CITY OF ALBUQUERQUE

**RE: Lot 5 Block 4 Volcano Cliffs SAD 228
6412 Papagayo Rd. NW
Grading and Drainage Plan
Engineers Stamp Date: 11/7/2022 (D10D003D5, HYDR-2025-00409)
CO Certification Date: 11/17/2025**

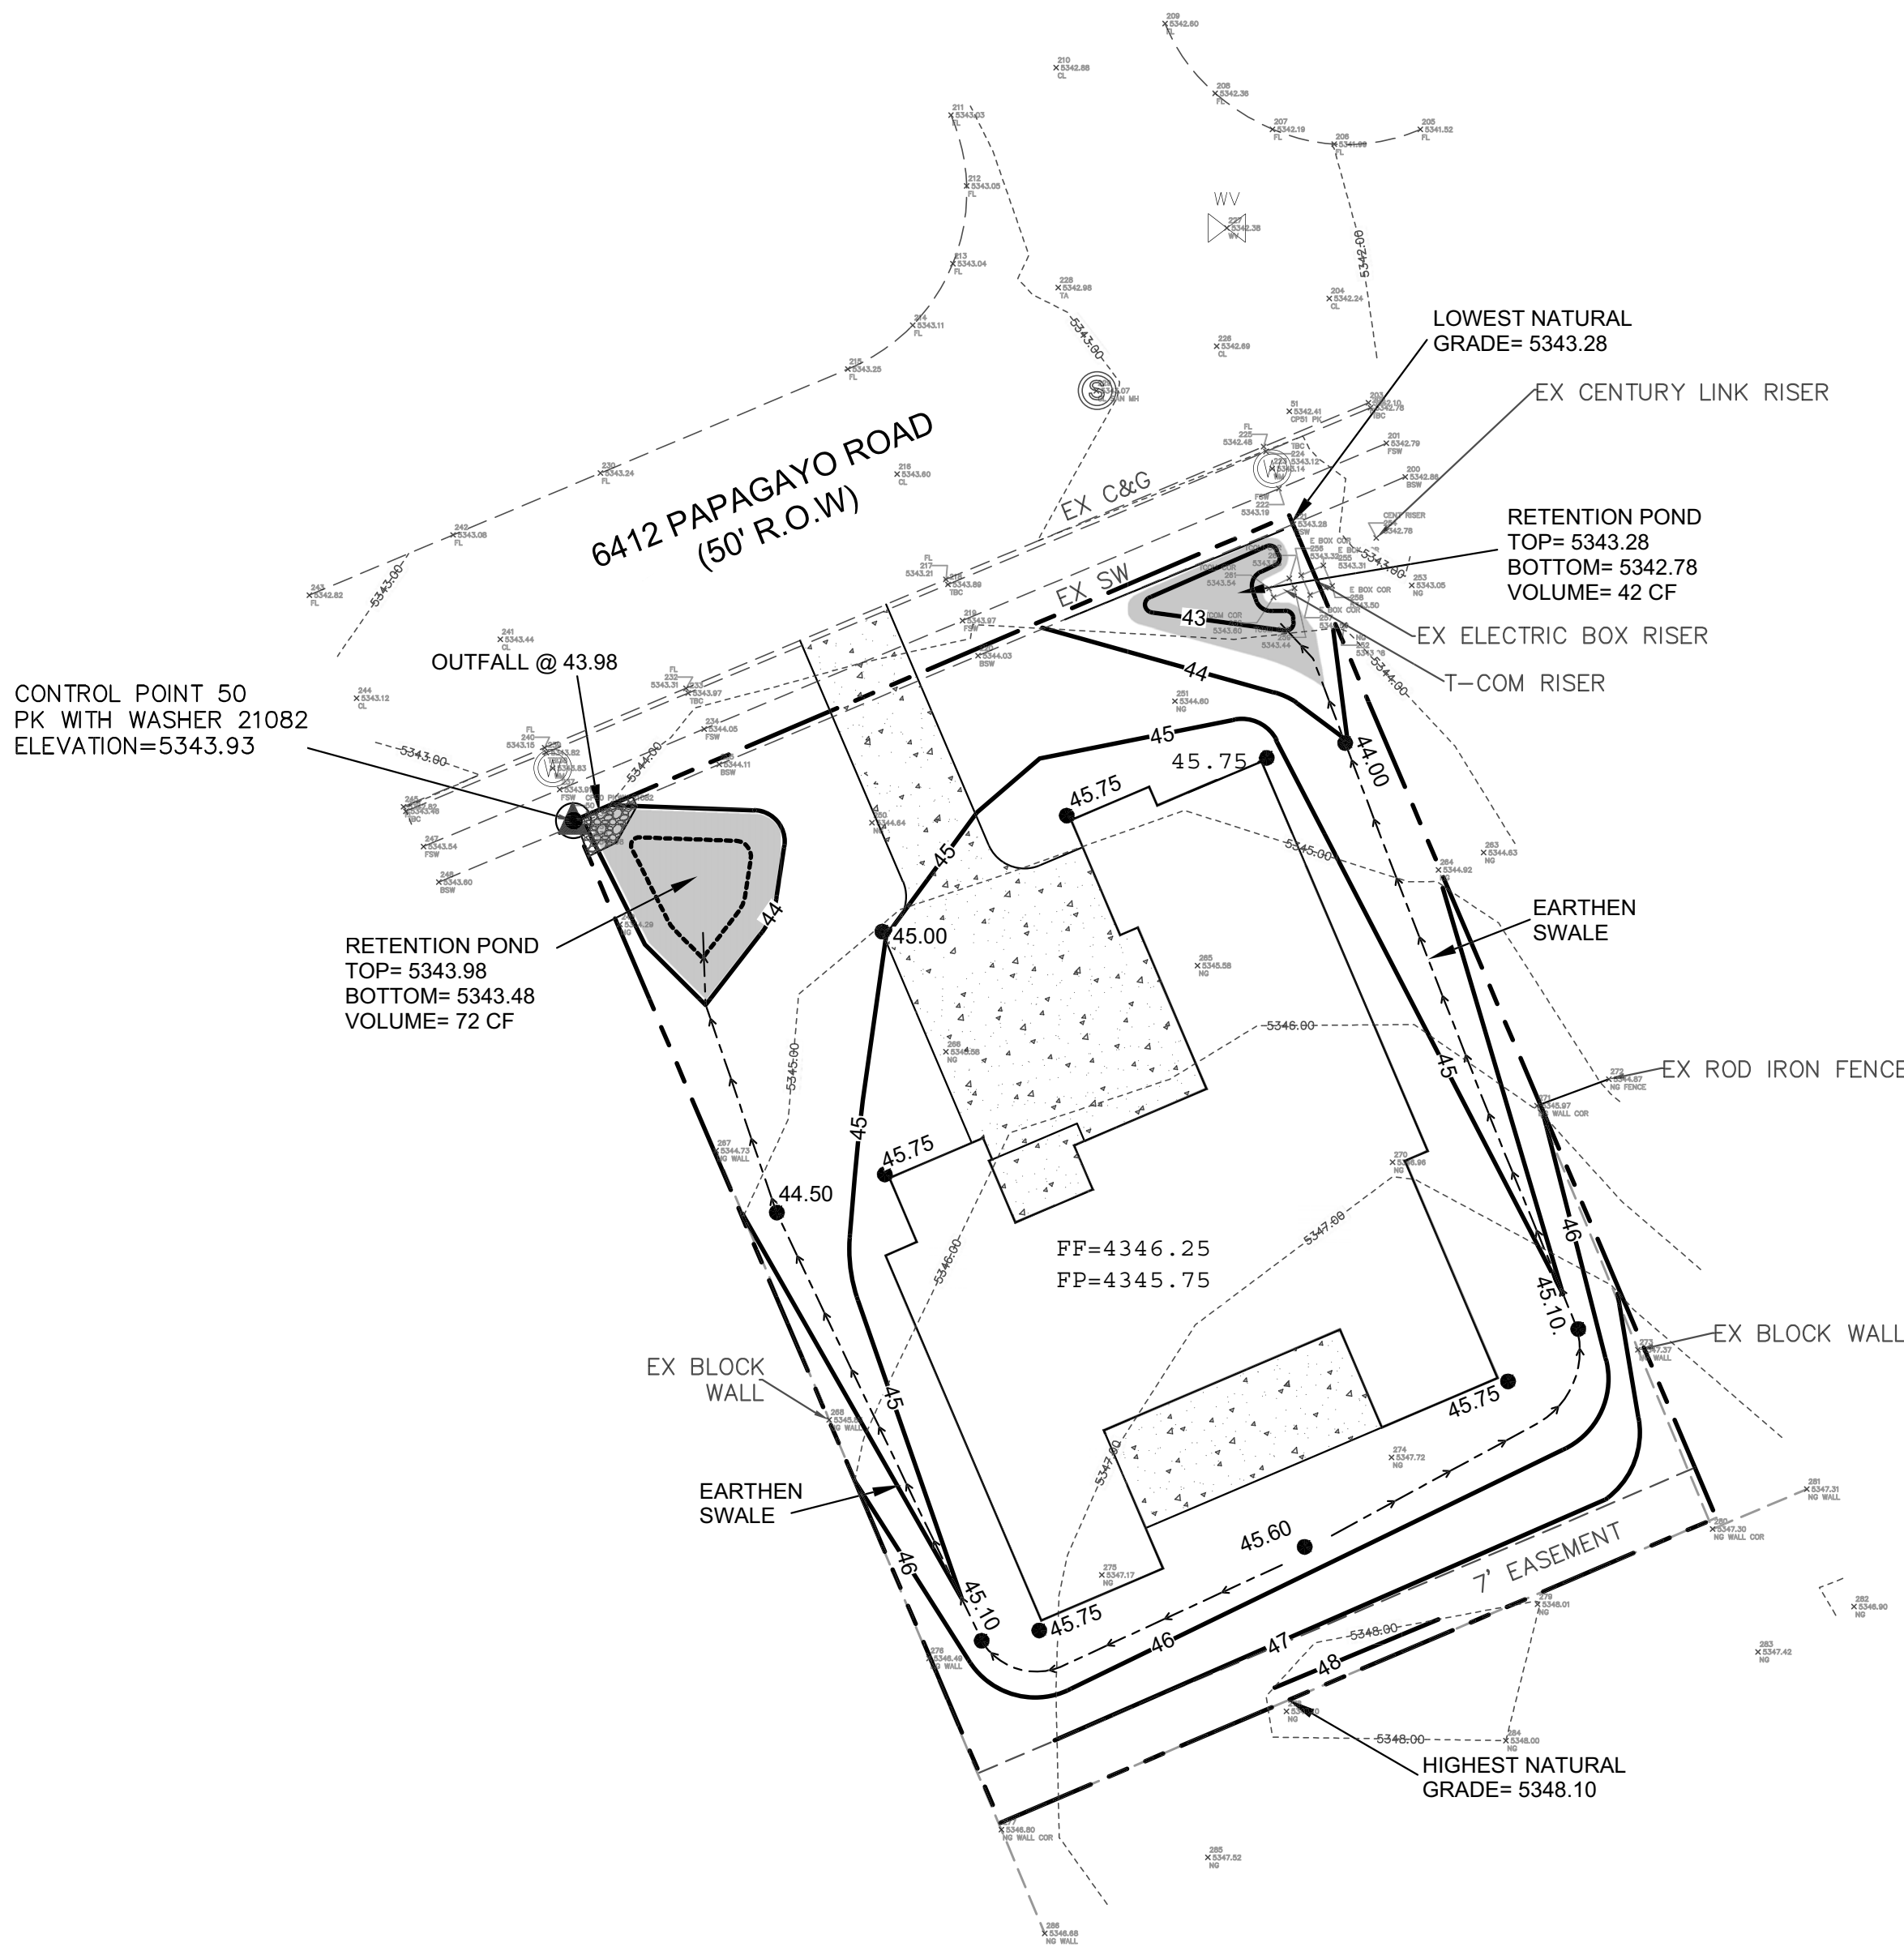
- North side of property drains into neighbors' yard, this needs to be remedied.
- Erosion control needs to be placed all around the home due to the slope around the home.
- Some areas need to be graded much better.
